Application Reference Number:	2025/0867.
--------------------------------------	------------

Proposal Description:	Erection of outbuilding (retrospective) to be used for golf simulator business.
Location:	5 Willow Bank, Barnsley, S75 1BN.

Ref. Dwg. No. Rev.  
**2025/29 CH02**

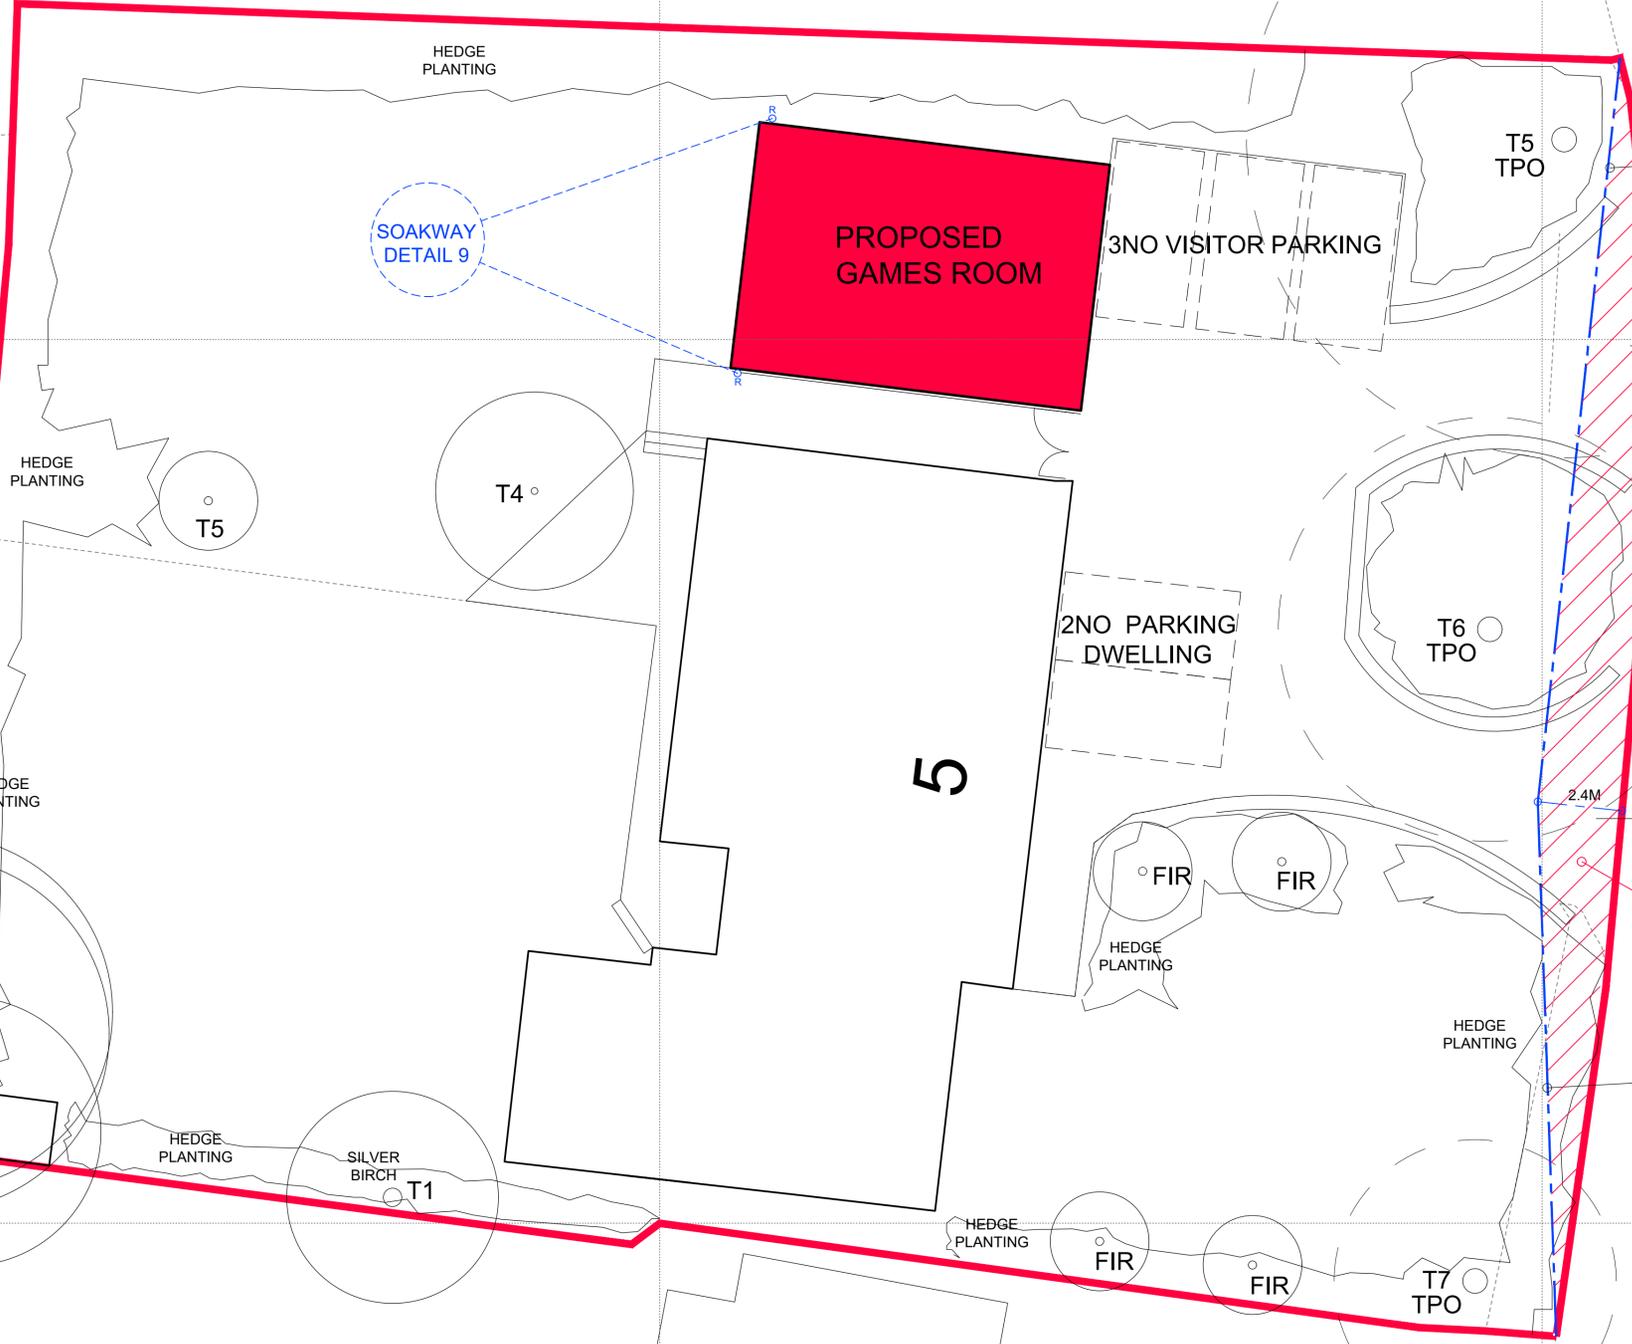
The application form indicates that 8no. off-street parking spaces would be provided within the site comprising of 5no. existing spaces and 3no. proposed new spaces. Highways Development Control were consulted whom initially sought clarity of where the spaces would be located. It was also noted that visibility could be limited from both existing access points due to the restricted width of the road and lack of footways. A parking layout plan was therefore requested. The Applicant was also asked to demonstrate that the proposed intensification of the site would not detrimentally impact on highway safety suggesting details of any mitigation measures should be provided.

The Applicant submitted an additional plan (2025/29 CH02) which demonstrates that 5no. parking spaces could be accommodated within the development site, which comprises 2no. spaces retained for the existing residential use and 3no. proposed spaces for the business use, in accordance with the Council's Parking SPD. The submitted details indicate the golf simulator is already in use and is regularly attended by family and friends. The intention to operate the facility as a business is primarily seen as a formalisation of the existing arrangements.

Highways Development Control were re-consulted, and it was stated that the proposal would unlikely result in any discernible increase in vehicular movements. Notwithstanding this, it was stated that to

mitigate against any intensified use of the development site, significant improvements to sight lines achieved from both existing access points are included within the proposal. Therefore, no objections were raised from a Highways Development Control perspective subject to conditions.

4. The sight lines indicated on the submitted plan (2025/29 CH02) shall be provided at the access junctions with Willow Bank, such that there is no obstruction to visibility at a height exceeding 0.9m above the nearside edge of the adjacent highway. Nothing shall be erected, retained, planted and/or allowed to grow at or above a height of 0.9m which would obstruct the sight lines, and they shall be always maintained free of obstruction thereafter for the lifetime of the development.

5. The parking/manoeuvring facilities indicated on the submitted plan (2025/29 CH02) shall be made available for the manoeuvring and parking of vehicles prior to the development being brought into use and shall be retained thereafter.

Ref. Dwg. No. Rev.
2025/29 CH01

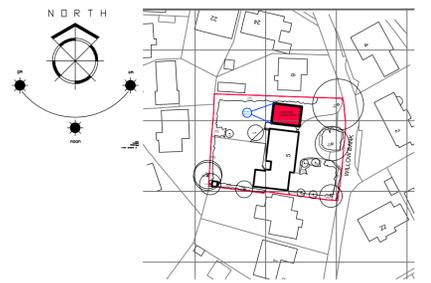
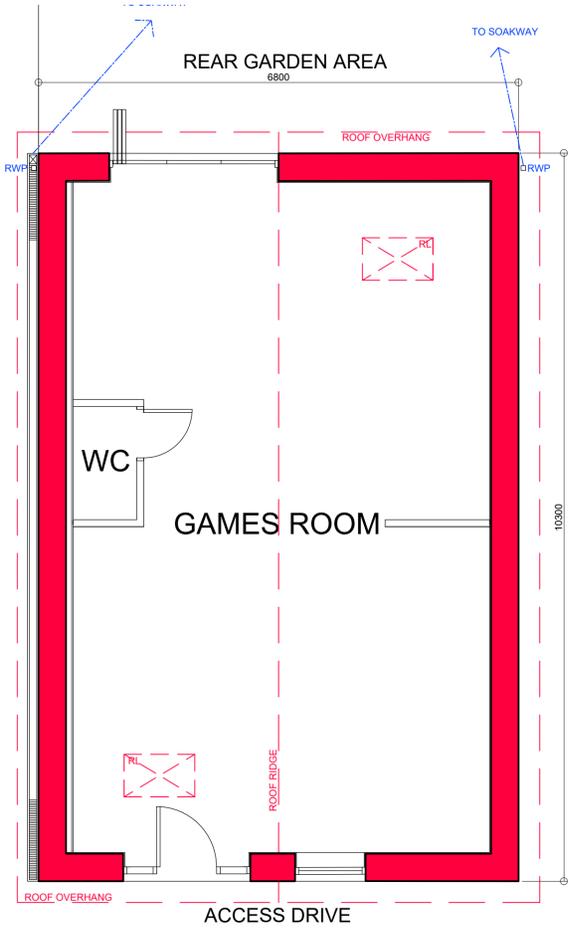
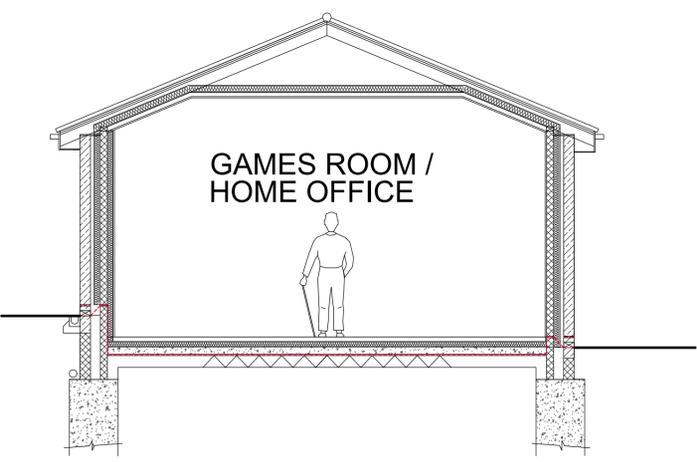
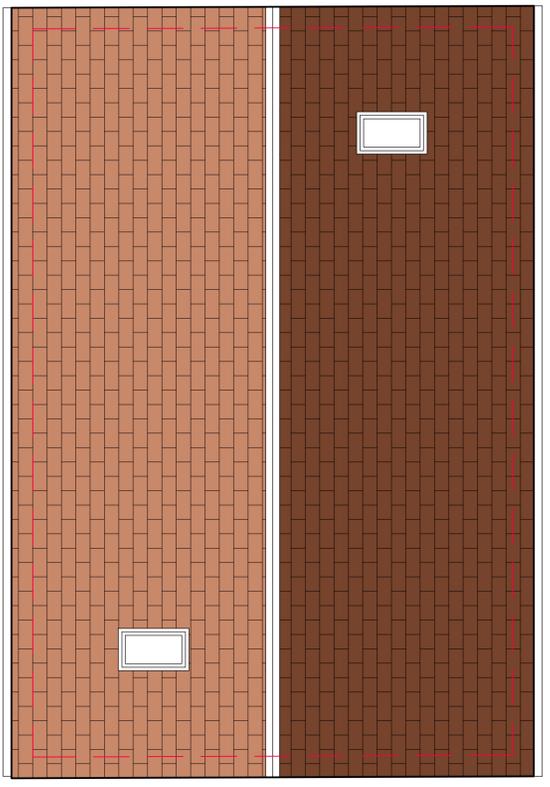
It is understood the outbuilding was not built in accordance with the approved plans under planning application 2024/0947 and as such, the Applicant is seeking planning permission retrospectively for the outbuilding as built. The differences include a slight reduction in width and increase in length and aperture size and placement.

The outbuilding as built measures approximately 6.8 metres (W) x 10.3 metres (L) x 4.7 metres (H) and is constructed of closely matching external materials comprising stone and roof tiles as approved under planning application 2024/0947.

It is not considered that the proposal would markedly alter or detract from the character of the street scene or application property. While there have been some minor alterations comprising a reduction in width, increase in length, and aperture size and placement compared with the previously approved scheme under planning application 2024/0947, they do not materially affect the external appearance of the outbuilding as previously approved, which has been constructed of closely matching external materials comprising stone and roof tiles and adopts a gable pitched roof. The previous assessment undertaken under planning application 2024/0947 regarding the impact on visual amenity therefore remains relevant and accurate, and the proposal remains acceptable in this regard.
